**From:** Abiel X. Carrillo  
**Sent:** Wednesday, February 03, 2016 10:22 AM  
**To:** Abiel X. Carrillo  
**Subject:** RE: E18D59 - San Antonio Commons - Stamp Date: 1-26-2016

**From:** Abiel X. Carrillo  
**Sent:** Tuesday, February 02, 2016 5:20 PM  
**To:** 'Larry Read'  
**Cc:** Olson, Paul L.  
**Subject:** E18D59 - San Antonio Commons - Stamp Date: 1-26-2016

Based upon the information provided in your re-submittal received 1-28-2016, the above referenced Grading and Drainage Plan cannot be approved for Grading Permit or Paving Permit until the following comments are addressed:

GRADING & DRAINAGE
PLAN

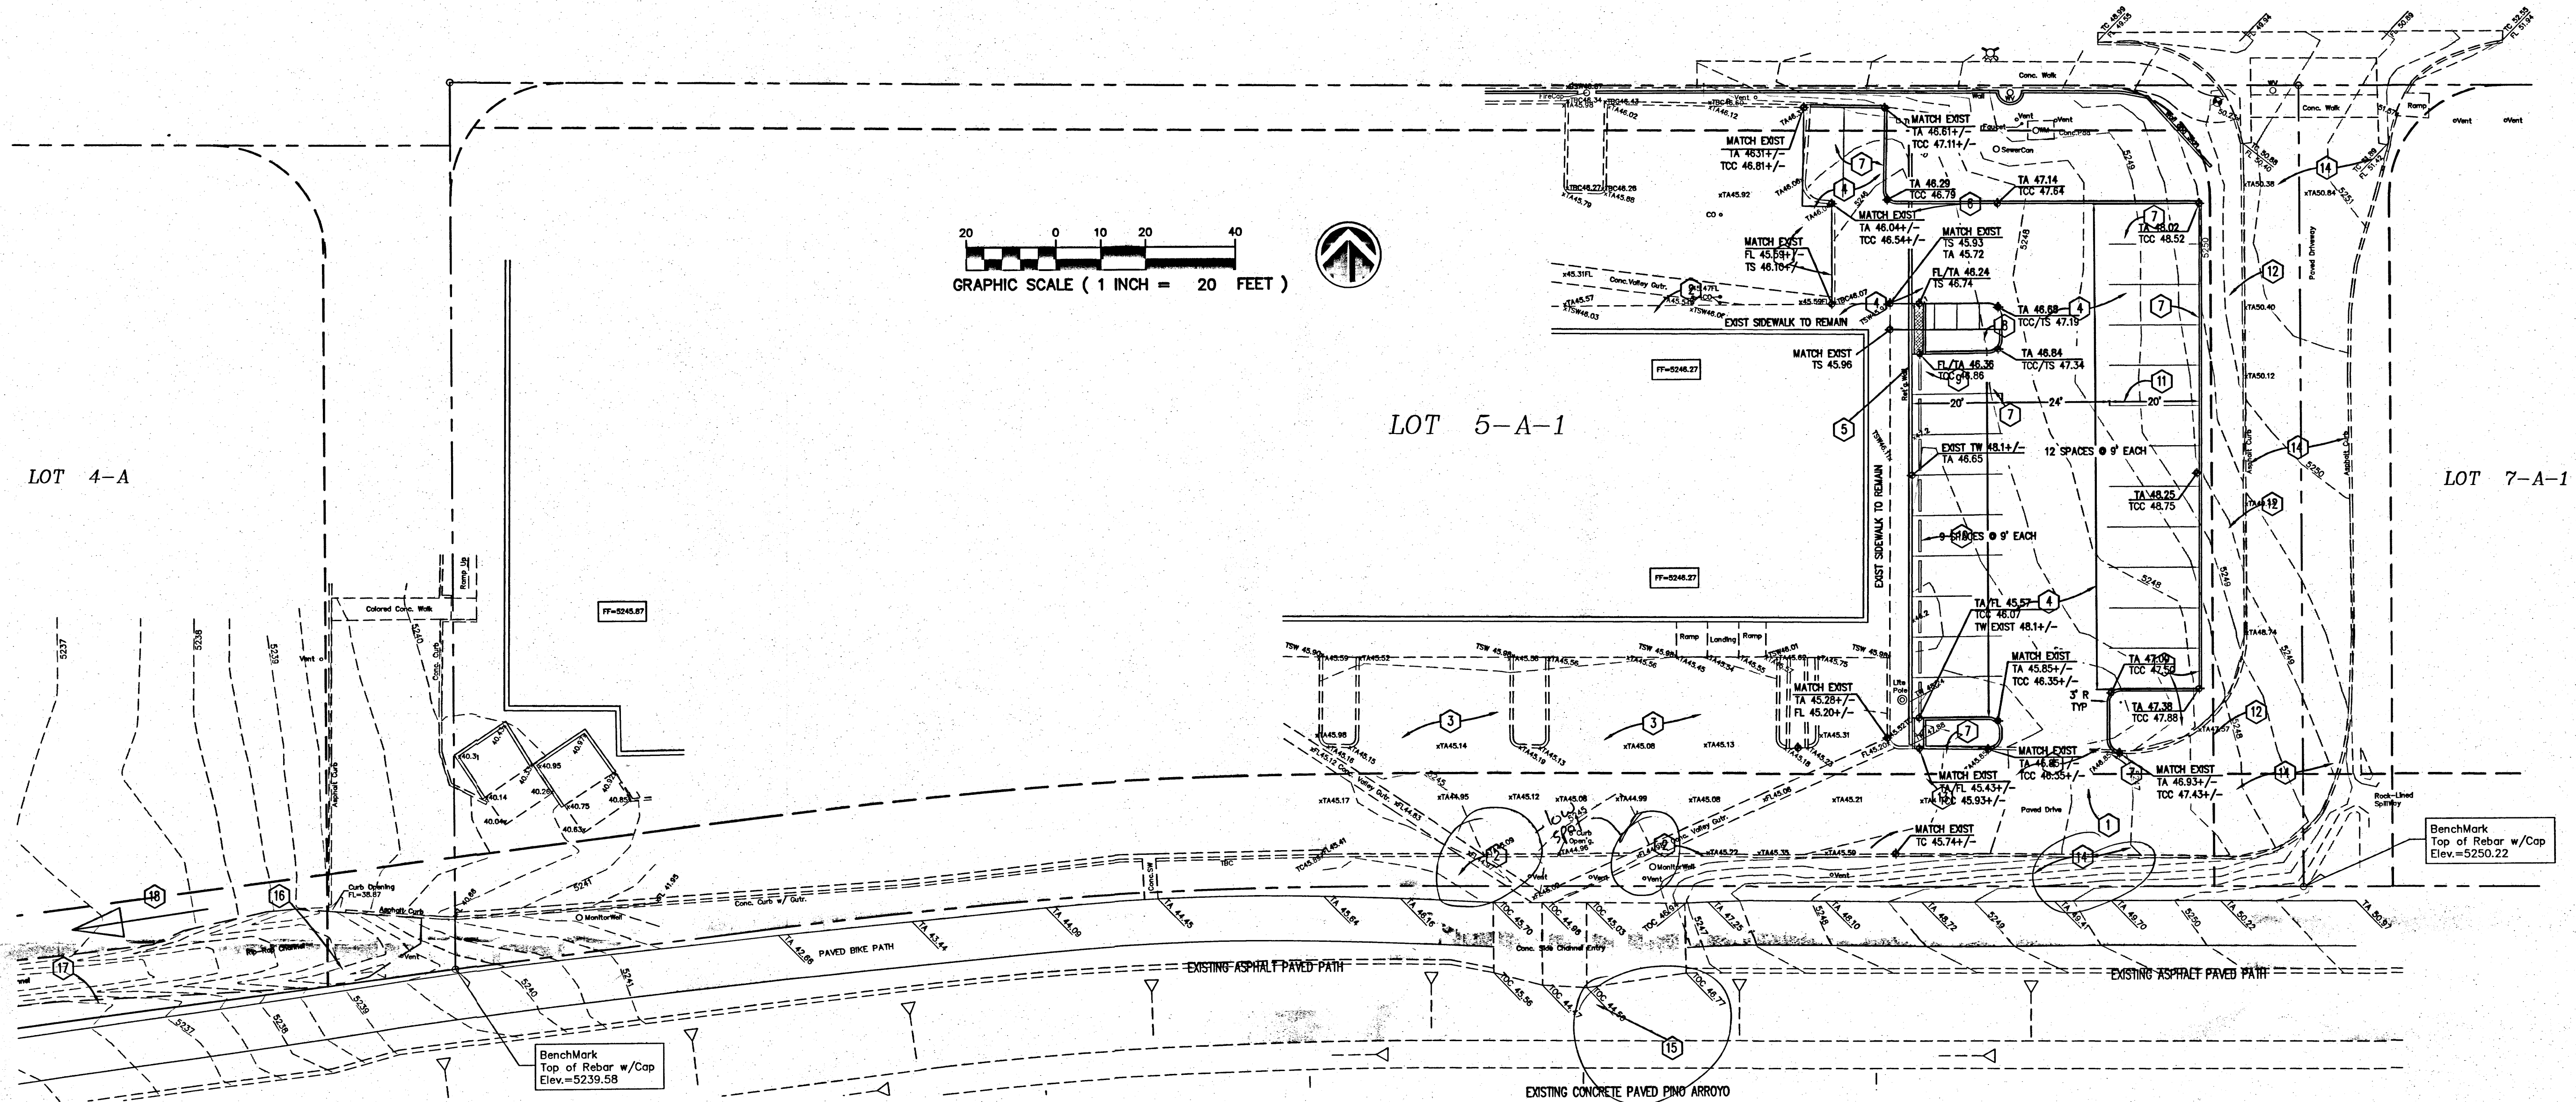
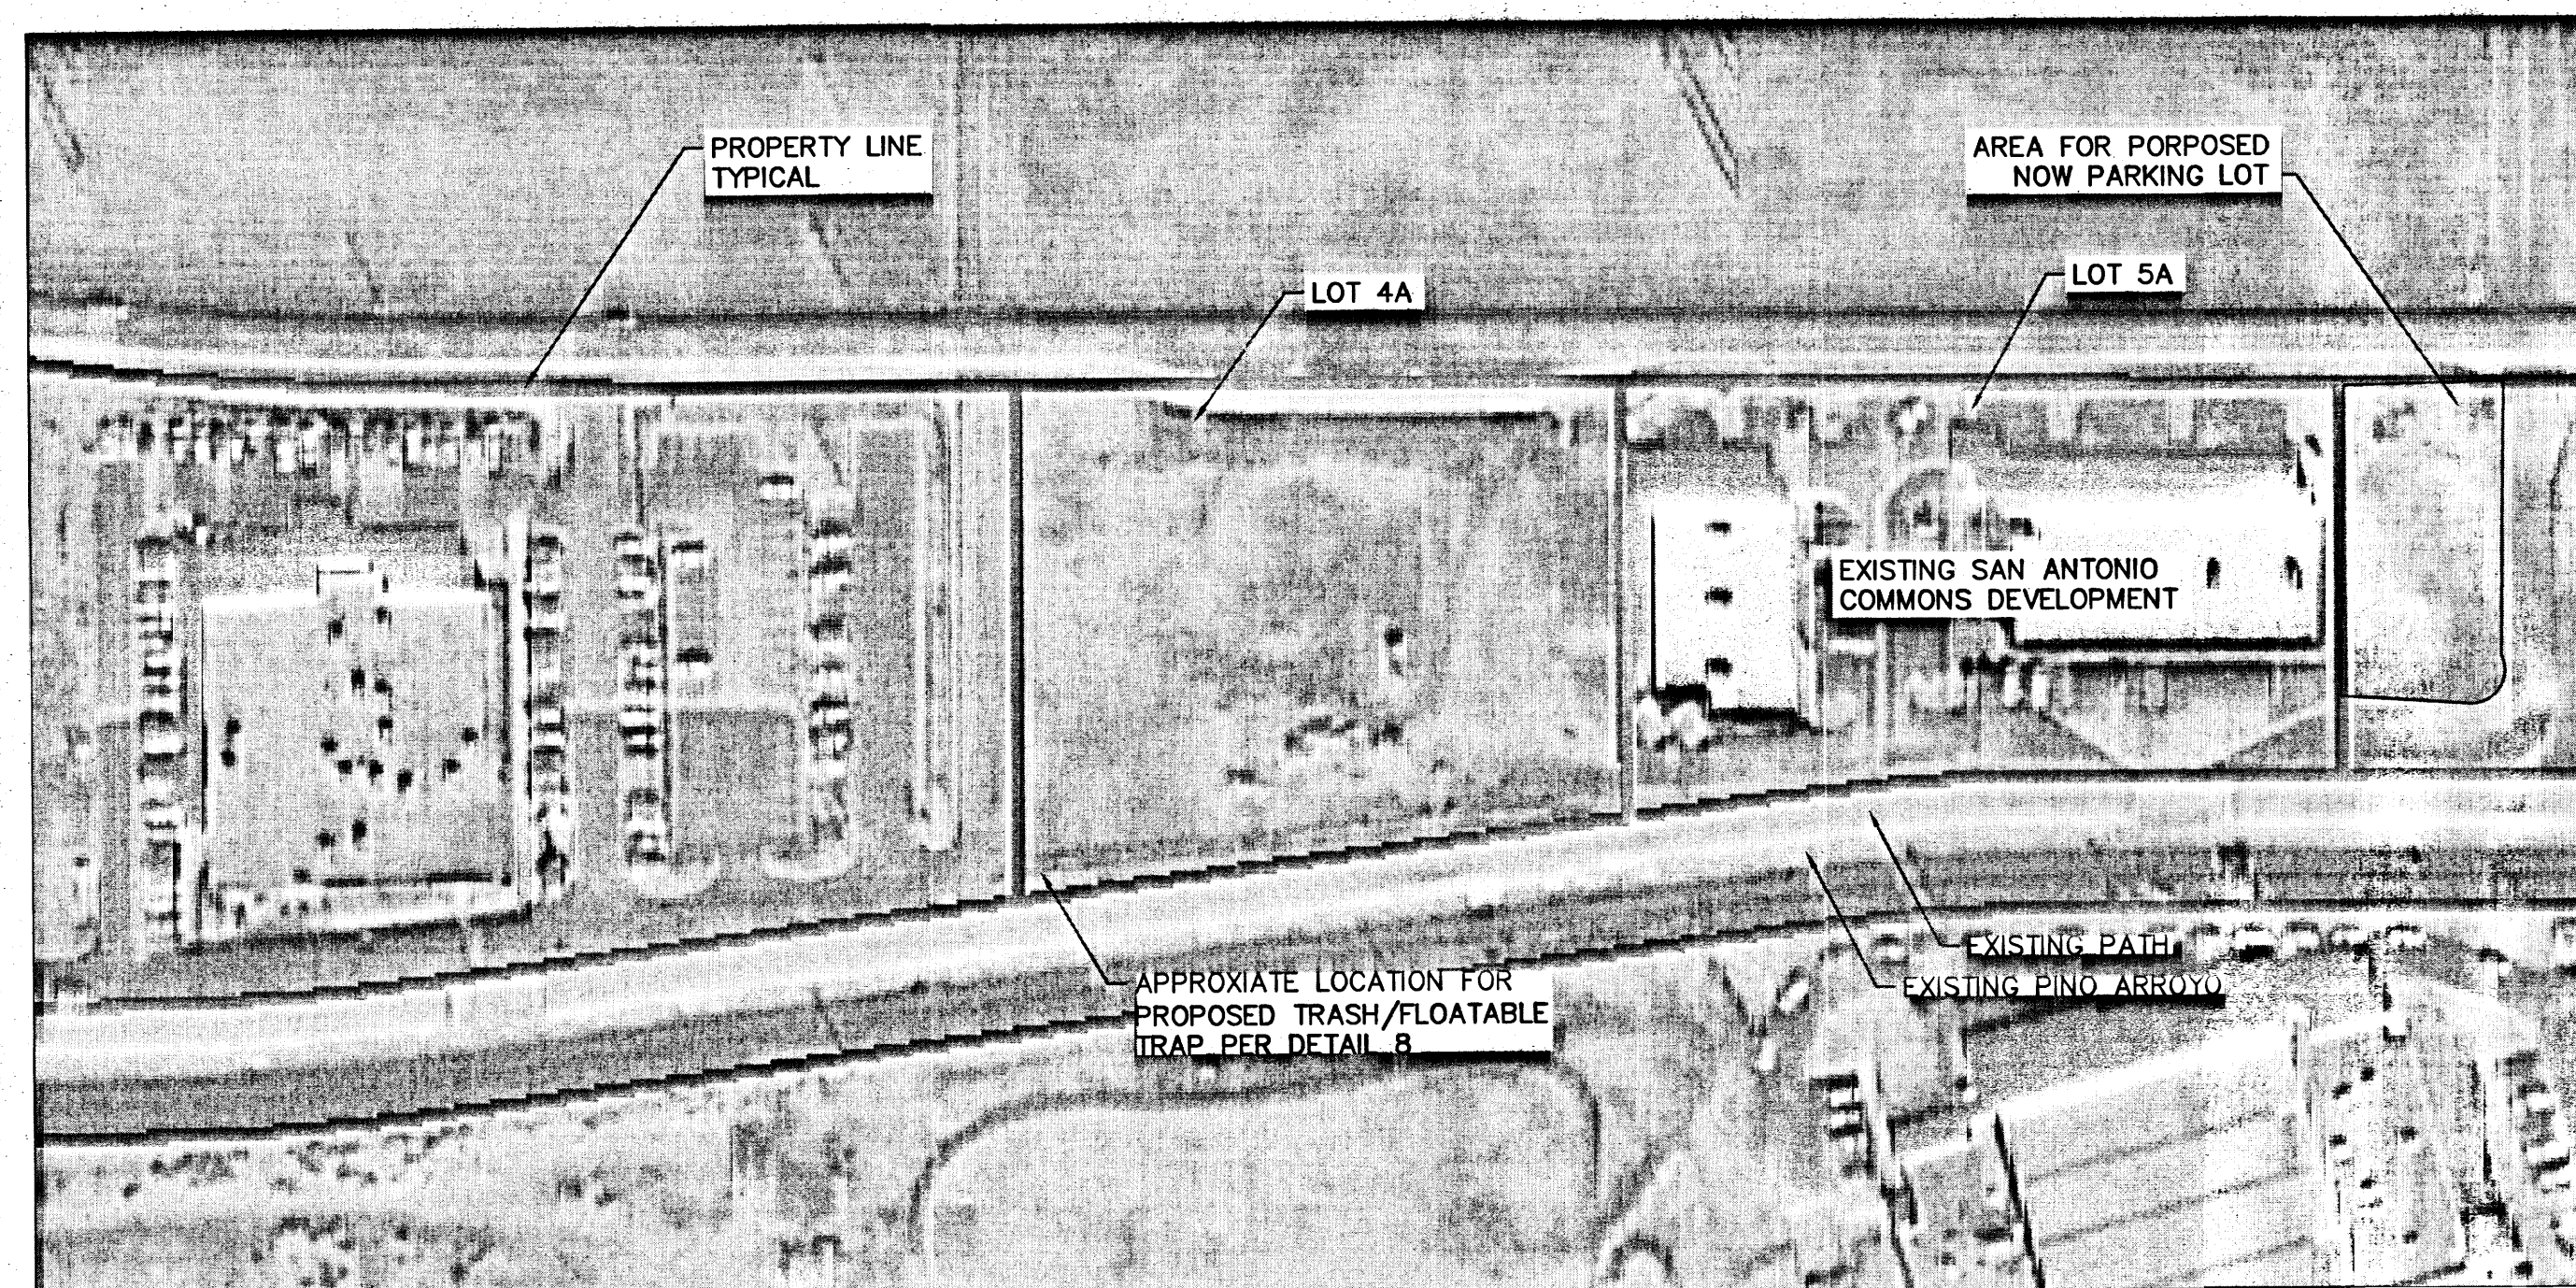
1. The comment provided by Hydrology on January 20, 2016, requested that the first flush storage tank shown for Lot 5A be replaced with a trash screen to ensure that the ground is not saturated. This submittal shows the pond removed, but a trash screen is not called out. The "Area Plan" aerial exhibit shows a trash screen approximately located at the corner of lot 4A. The trash screen needs to be drawn in at the exact location of the outfall of the valley gutters to ensure that the contractor builds it as intended.

2. The previous submittal, which showed the first flush pond, would have removed a segment of the existing valley gutters that have low spots (Elevations 44.97 and 44.98 along the valley gutter, but outfall is at 45.02). These segments (and any asphalt adjacent to them that may also be low) will need to be corrected to best comply with the Environmental Health Department's request to prevent any ponding on this site. *Will create an outlet to the rip rap channel.*

3. Minor comment: The keyed notes (such as 12 and 15) appear to be shifted away from the improvements they are pointing to.
